## **RESPONSE TO REQUEST FOR FURTHER INFORMATION WOOLWORTHS WAREHOUSE AND CUSTOMER FULFILMENT CENTRE, MARRICKVILLE (SSD-10468)**

This letter responds to the Request for Additional Information ('RFI') letter issued by the Department of Planning and Environment ('DPE') dated 10 November 2021.

Table 2 – Response to Inner West Council Response to Submissions Report

Drawing Name
Street Tree Viability Study
Sections

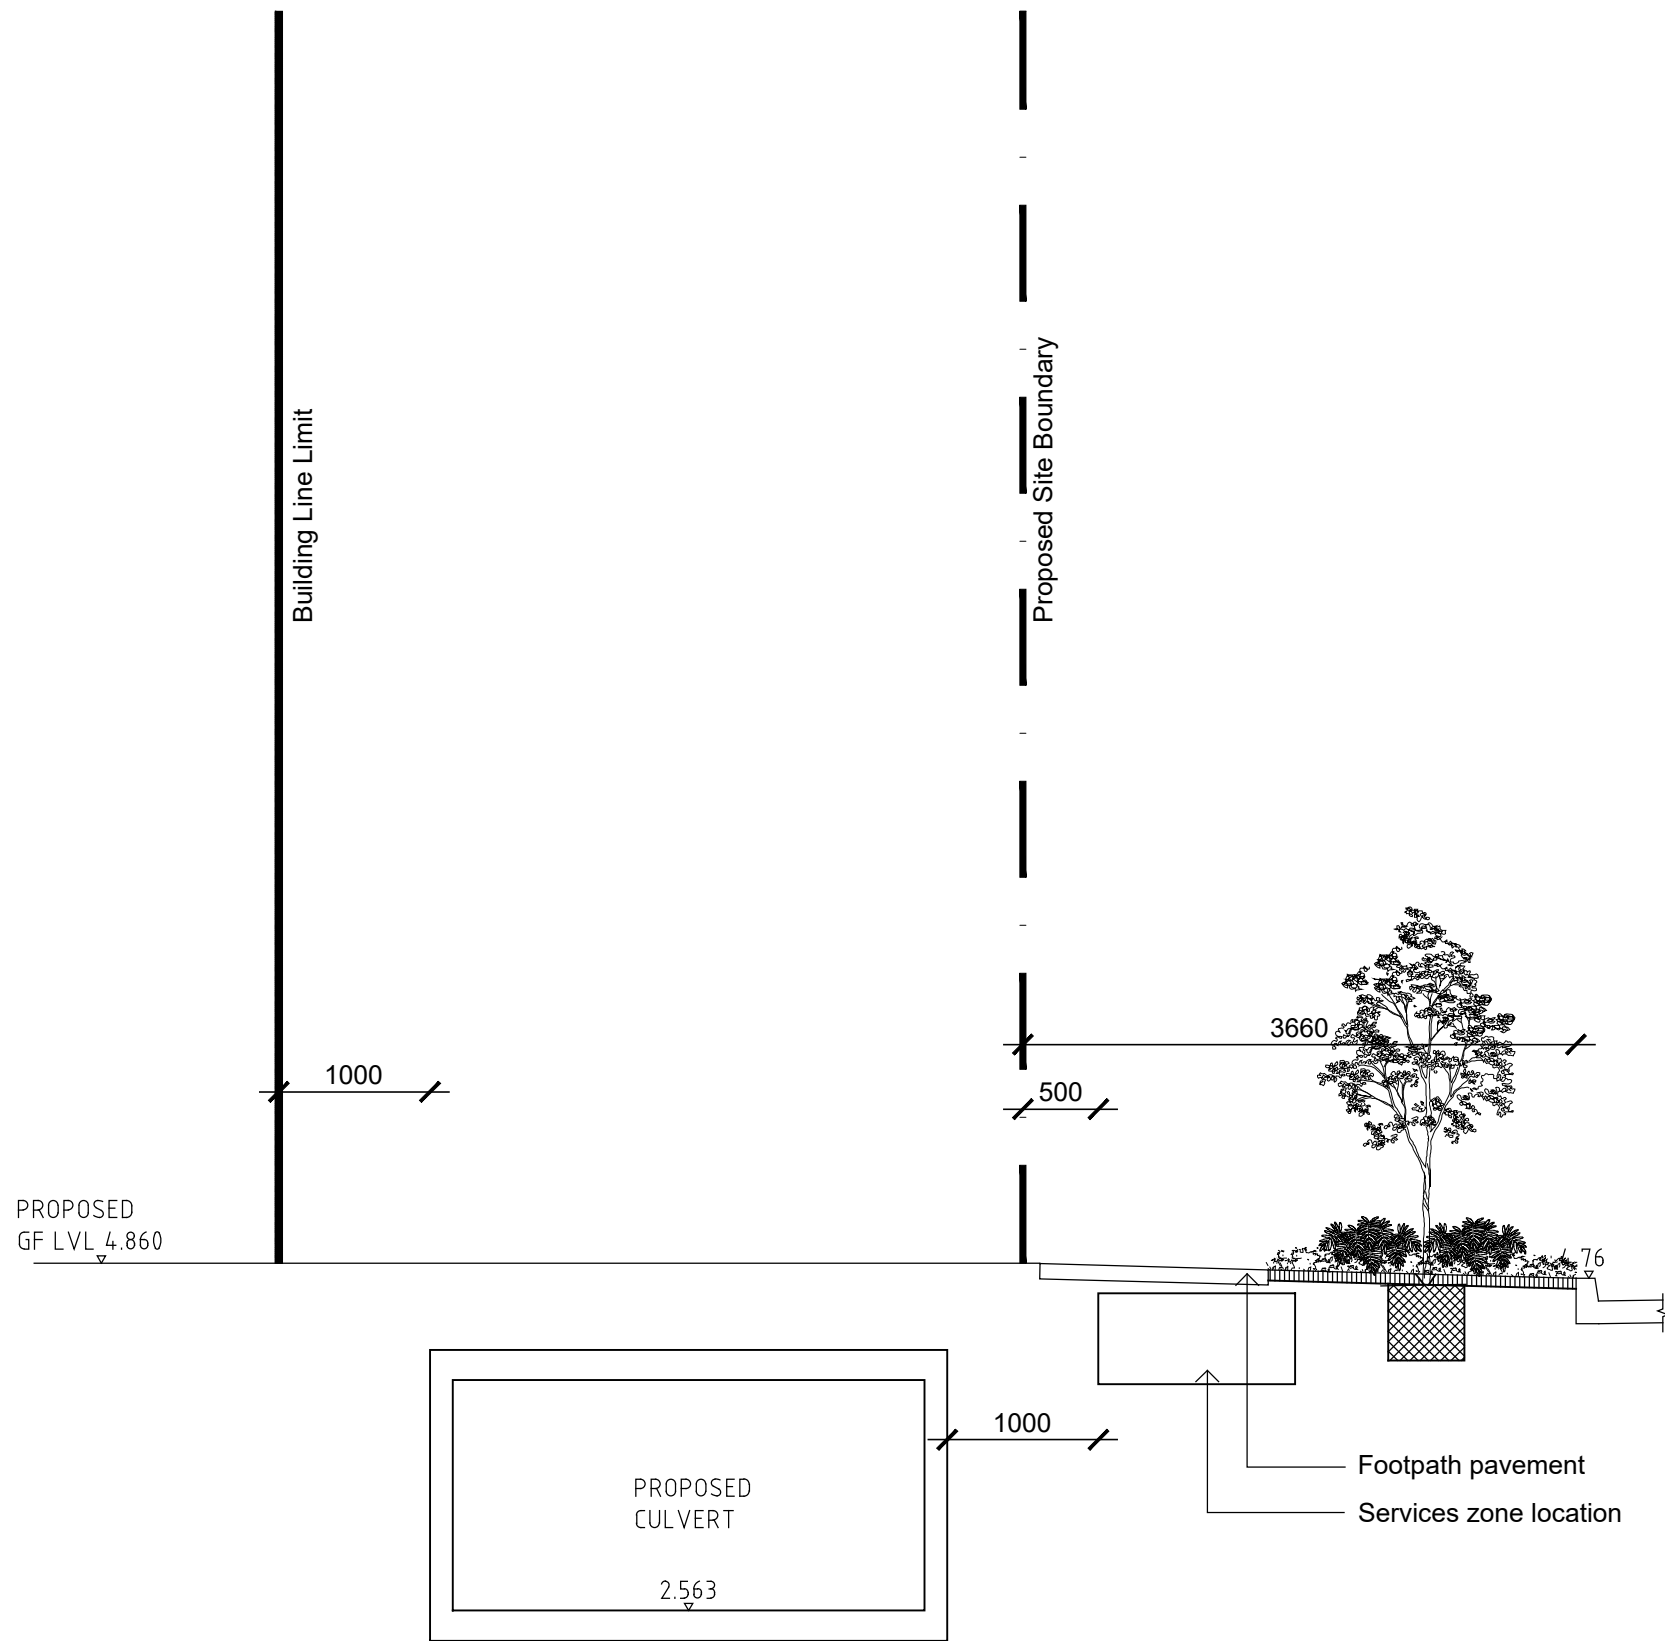
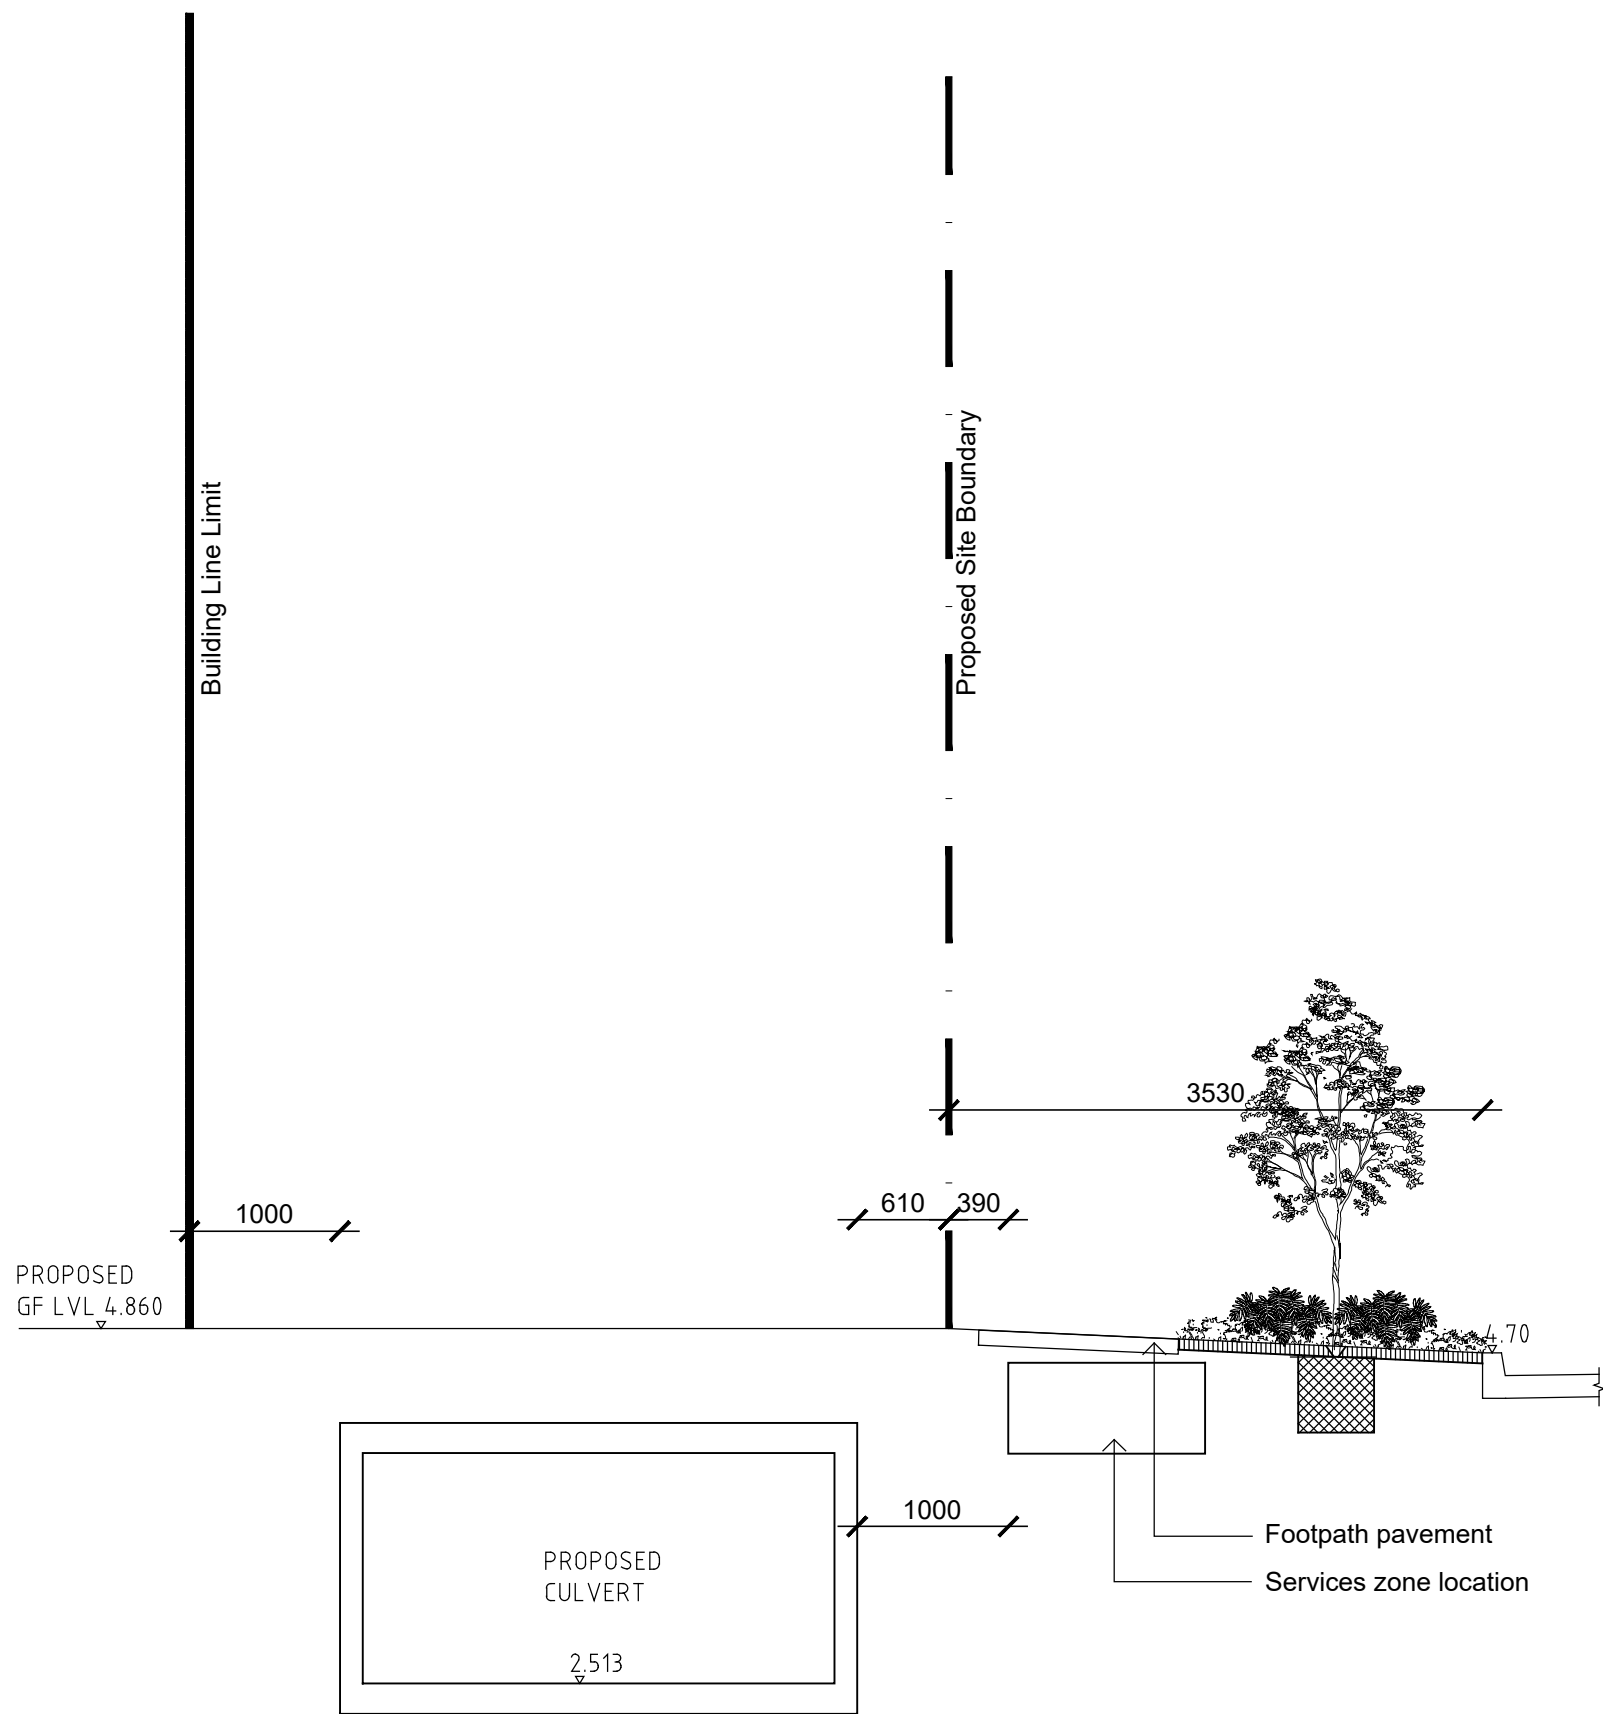
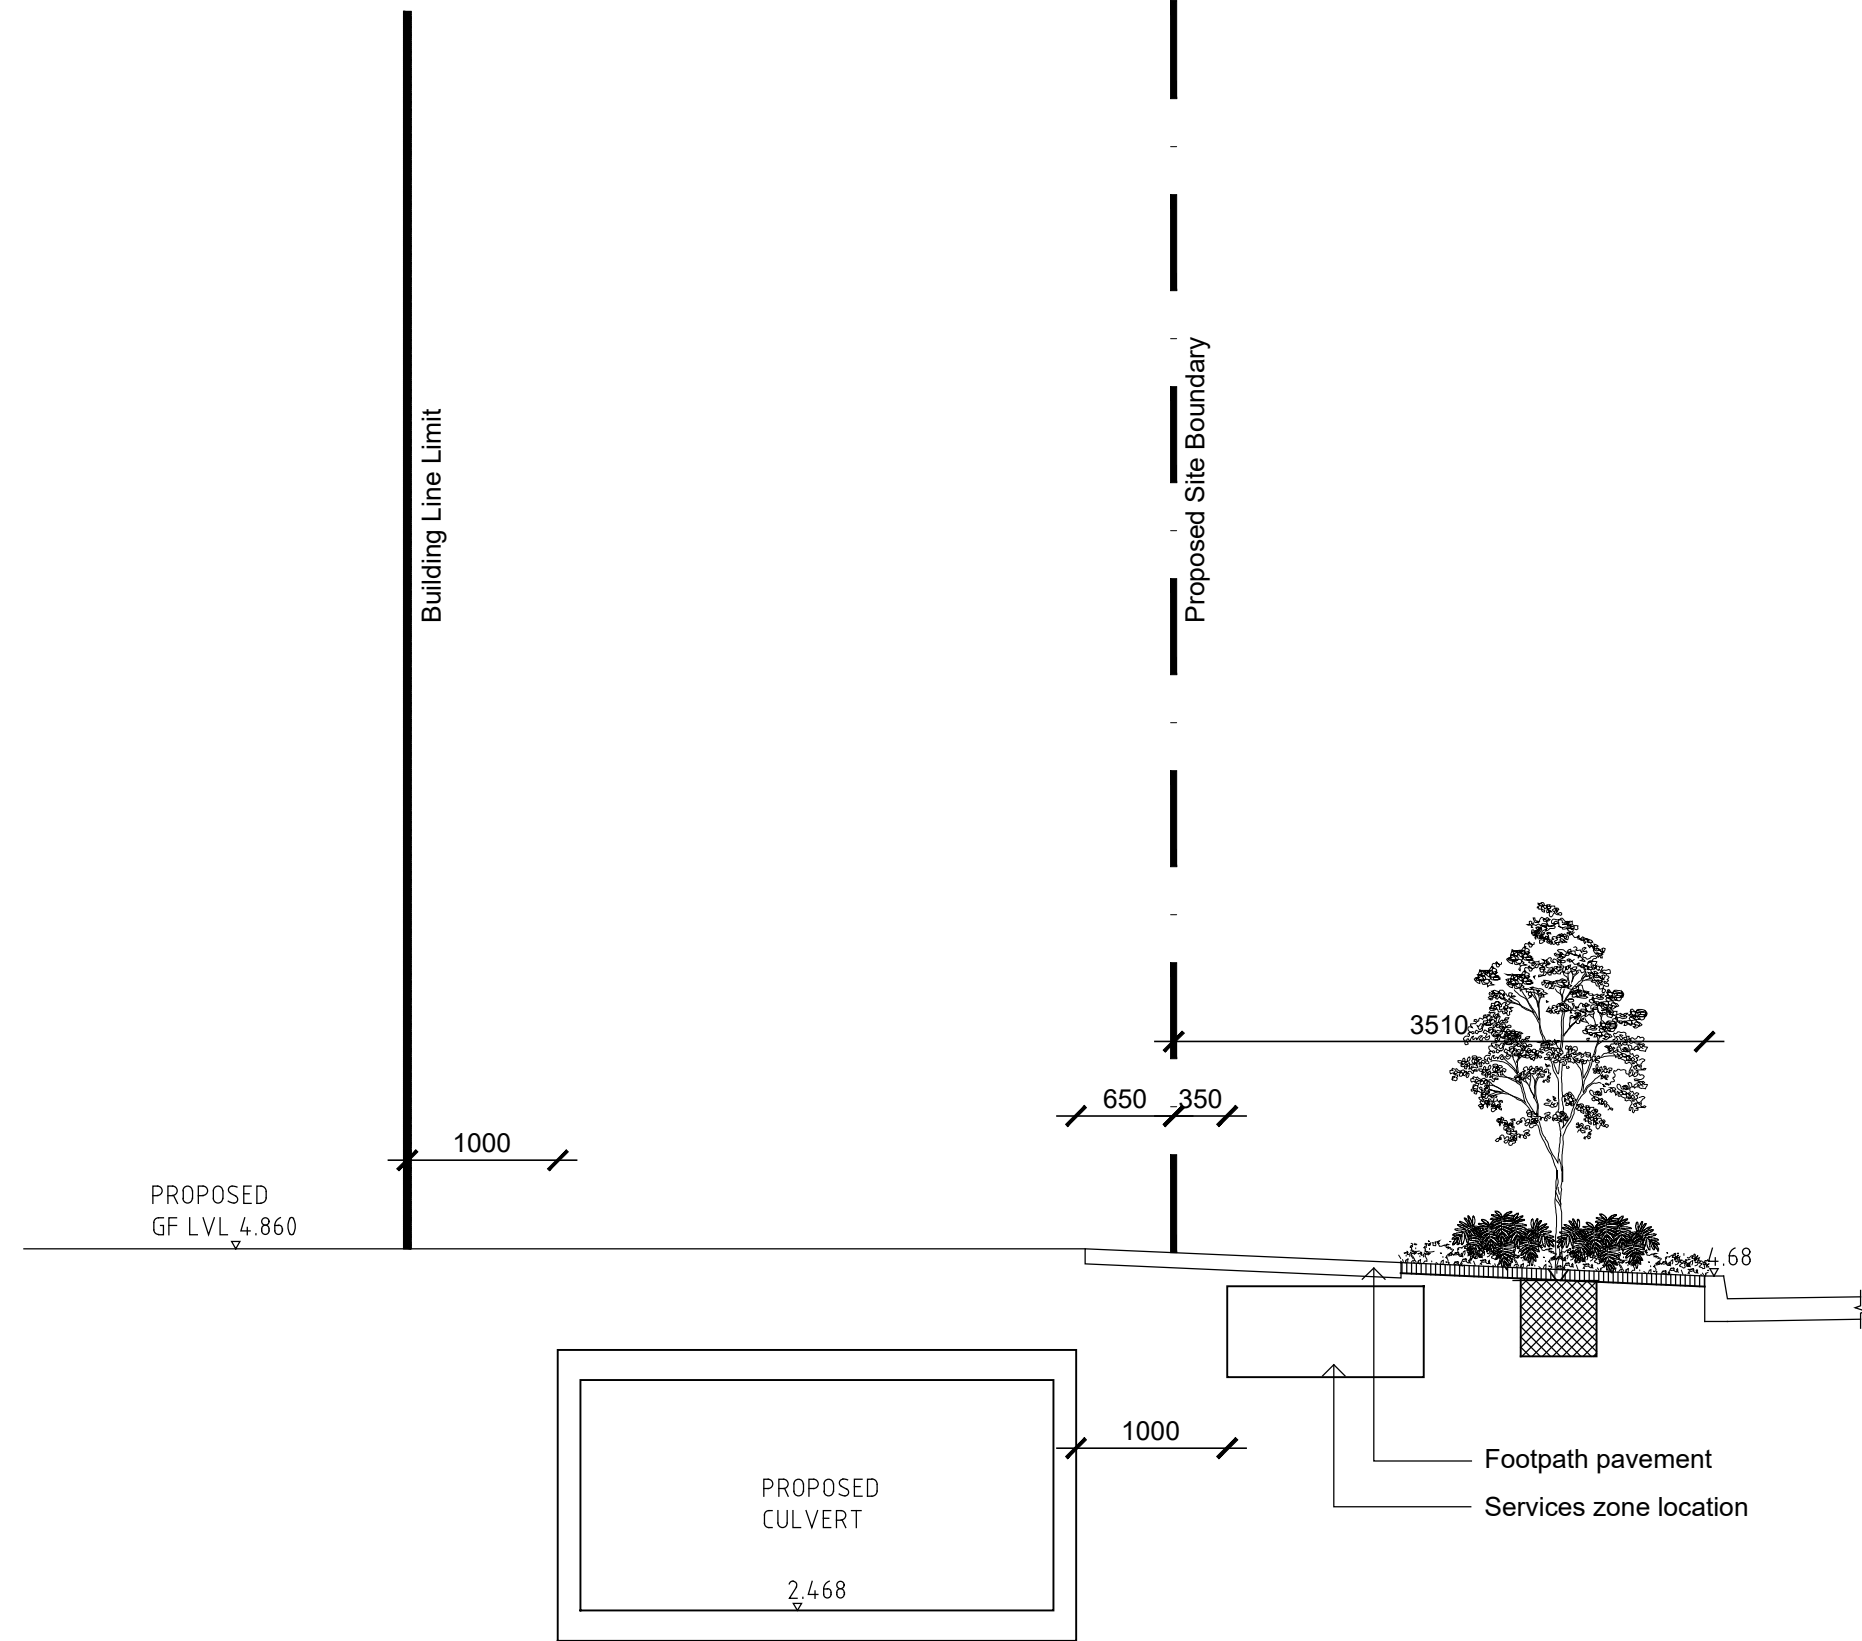
<p>vii. Relocation of stormwater culvert – The proposed location of the culvert is not supported because of the direct impact this will have on soil volumes available for the replacement streets on Edinburgh Road and internal landscape trees along this street frontage. The culvert location must be amended so that required deep soil volumes for trees are not constrained. The removal of the existing trees cannot be supported unless the trees are to be replaced in a viable growing environment.</p>	<p>The stormwater culvert has been realigned to be located within the property boundaries, enabling new street trees to be delivered within the road reserve.</p> <p>Updated landscape drawings have been prepared by Site Image dated 24 February 2022 (Rev F) which include the new stormwater channel location and the proposed street trees.</p> <p>The updated site plan (refer Sheet 401) shows the proposed location of the new street trees along the Edinburgh Road and Sydney Steel Road frontages. The sections</p>

Comment	Response
	<p>(refer Sheet 402) show the separation distances between the proposed culvert and the service zone location, footpath pavement and street tree planting along the Edinburgh Road frontage. Additional details regarding the tree soil volume areas for both the on-site and street tree planting has also been provided (refer Sheets 701-703).</p>
<p>viii. Soil volumes for trees – The Landscape Plans/Landscape Report must include soil volume calculations demonstrating that street trees and site trees have sufficient soil volumes to allow for the development of healthy root systems. Note – Medium trees ideally require approx. 27-38m<sup>3</sup> and large trees approx. 27-39m<sup>3</sup> (each) depending on soil conditions. Where trees are planted in shared contiguous planting zones and irrigated the soil volumes may be able to be reduced.</p>	<p>Updated landscape drawings have been prepared by Site Image dated 24 February 2022 (Rev F) including additional details regarding the tree soil volume areas for both the on-site and street tree planting (refer Sheets 701-703).</p> <p>The soil volumes are calculated based on the planter bed area and a depth of 1 metre. Where multiple trees share a planter bed, the volume has been divided by the number of trees to provide the volume per tree. These calculations are conservative, noting additional soil depth is available where trees are planted on grade and can access soil in adjacent areas.</p> <p>Overall, it is considered sufficient soil volume will be available to facilitate the development of healthy root systems based on the proposed site conditions, including the garden beds and additional soil volumes in adjacent areas.</p>
